# FOREST HEIGHTS ESTATES GRADING & EROSION CONTROL PLANS

FOR FOREST HEIGHTS CIRCLE  
COUNTY OF EL PASO, STATE OF COLORADO

**FOREST HEIGHTS CIRCLE GRADING & EROSION CONTROL PLAN**  
GENERAL NOTES AND EROSION CONTROL DETAILS

Project No.: 18070
Sheet: 2 of 4

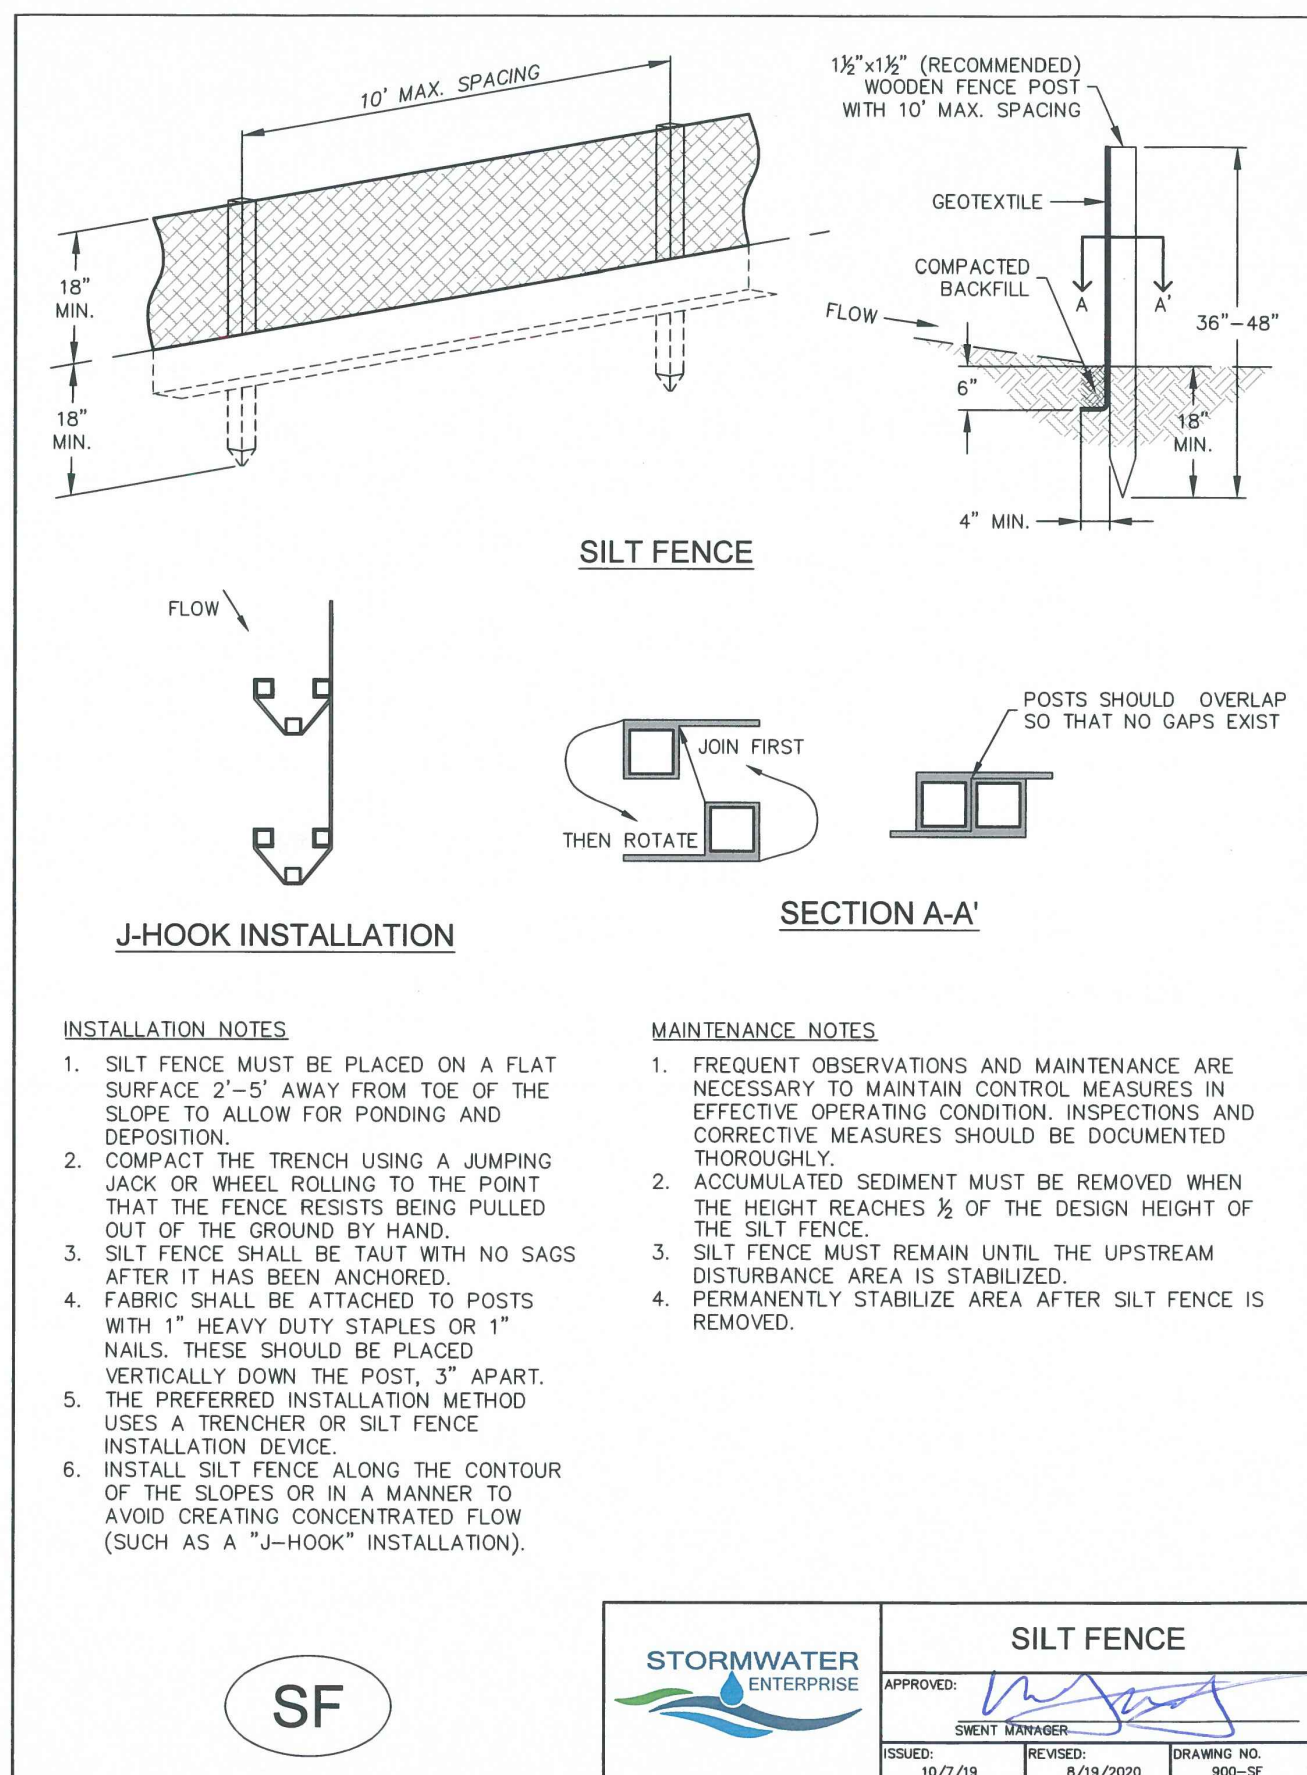
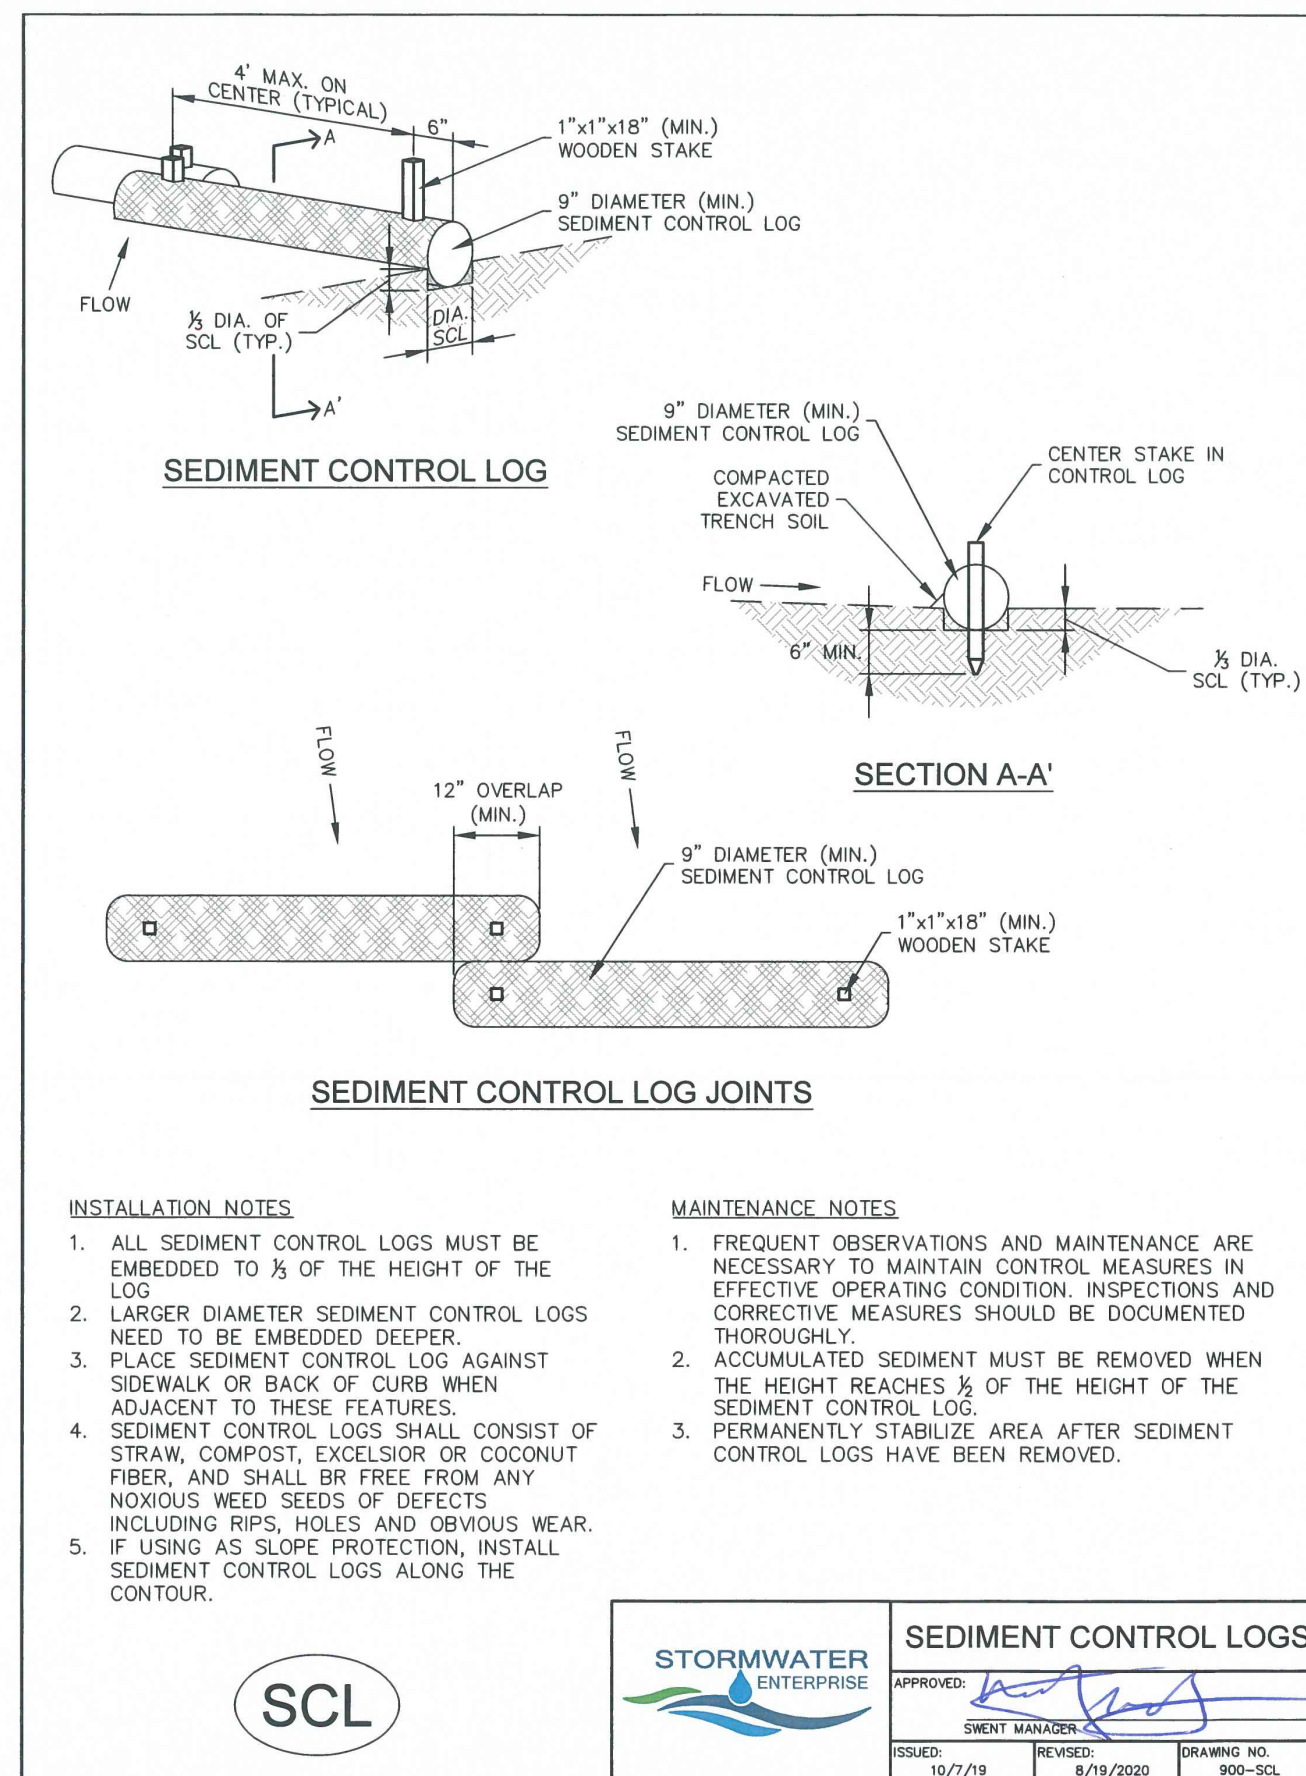
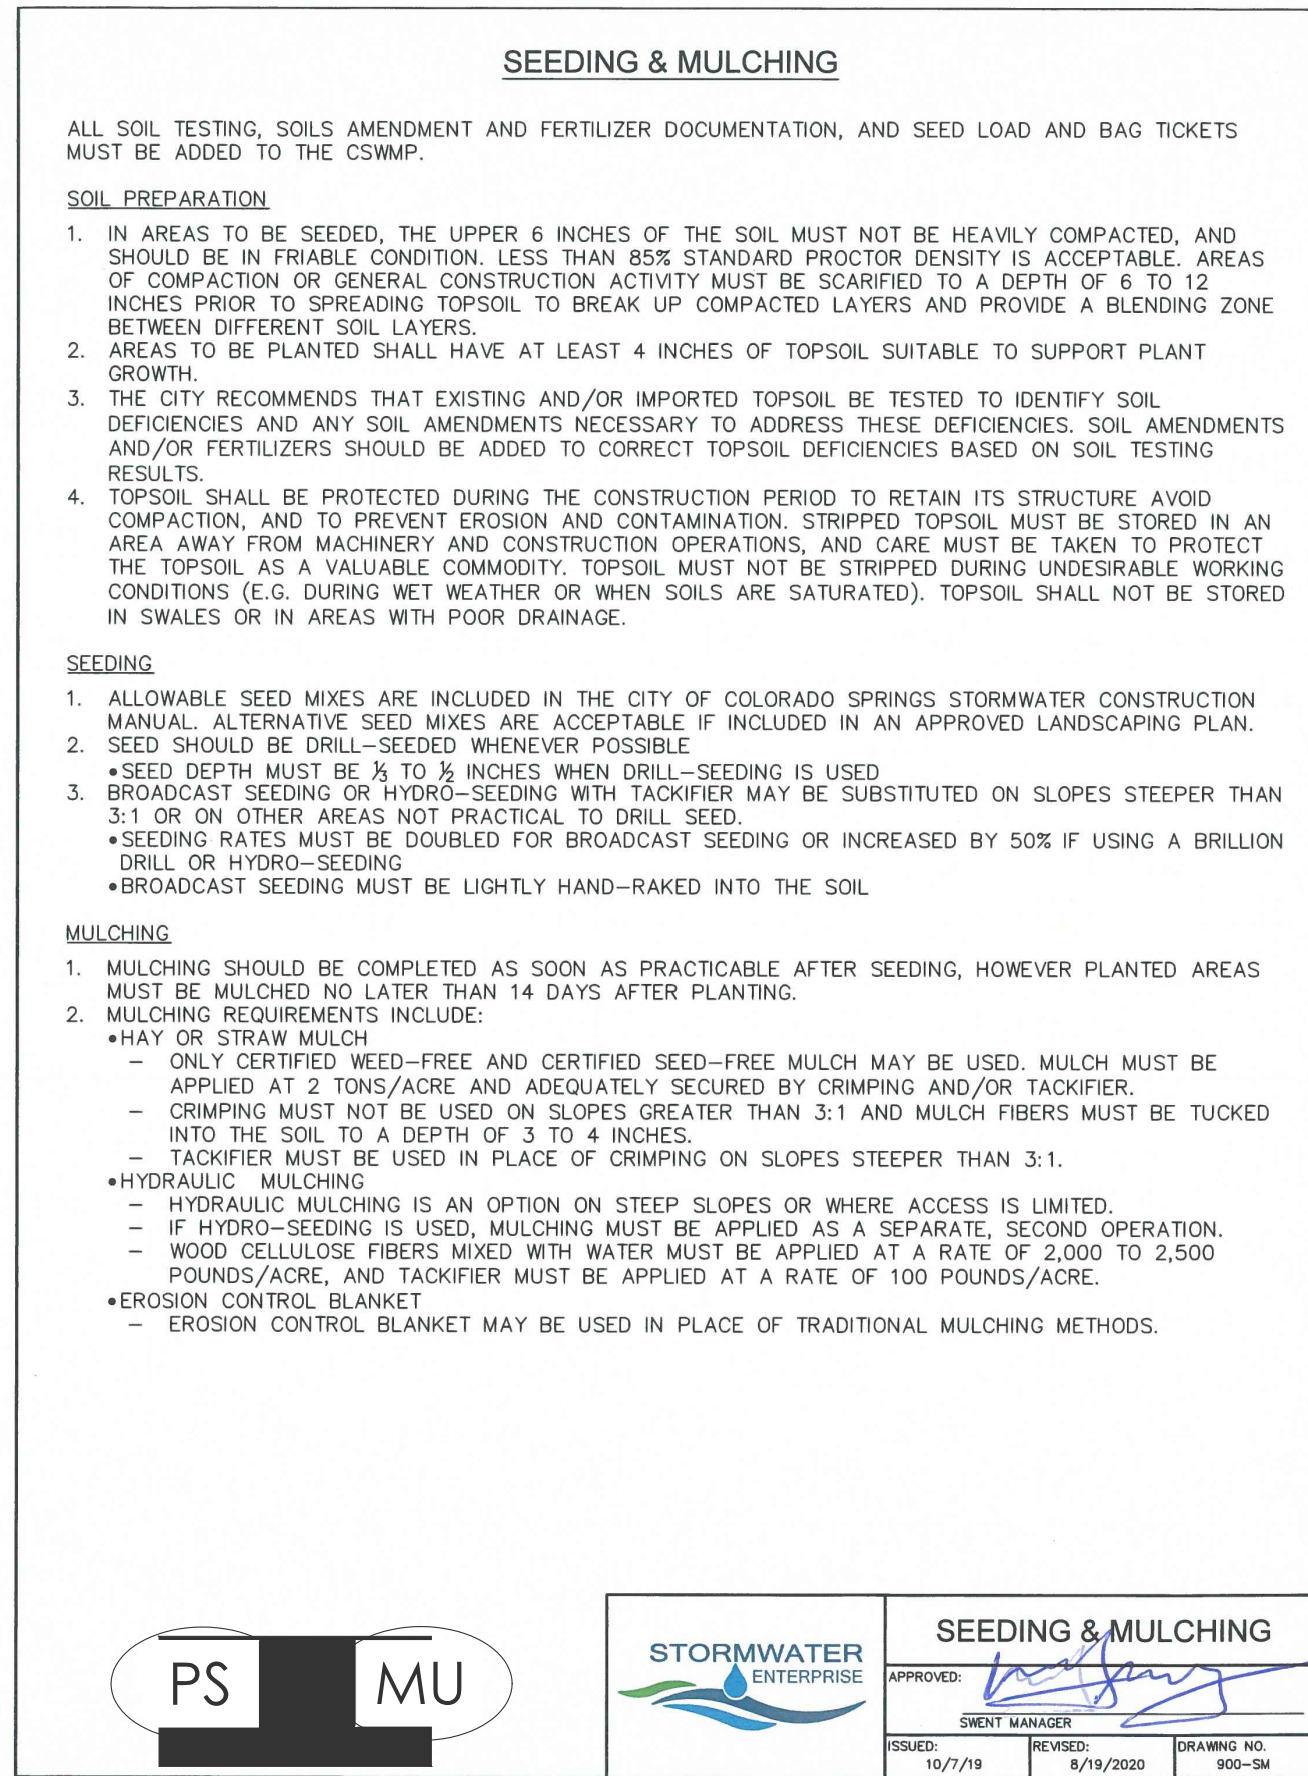
does not match note on Sht 4 below. Revise to remove discrepancy.

Unresolved previous comment from Review #2: If a VTC is added to the plans above, add a VTC detail to this sheet. And make sure to use a EPC approved VTC detail (VT-1 and VT-2 in DCM V2, Chap 3.3) or revise other detail (which usually have 50ft length) to be 75ft min length.
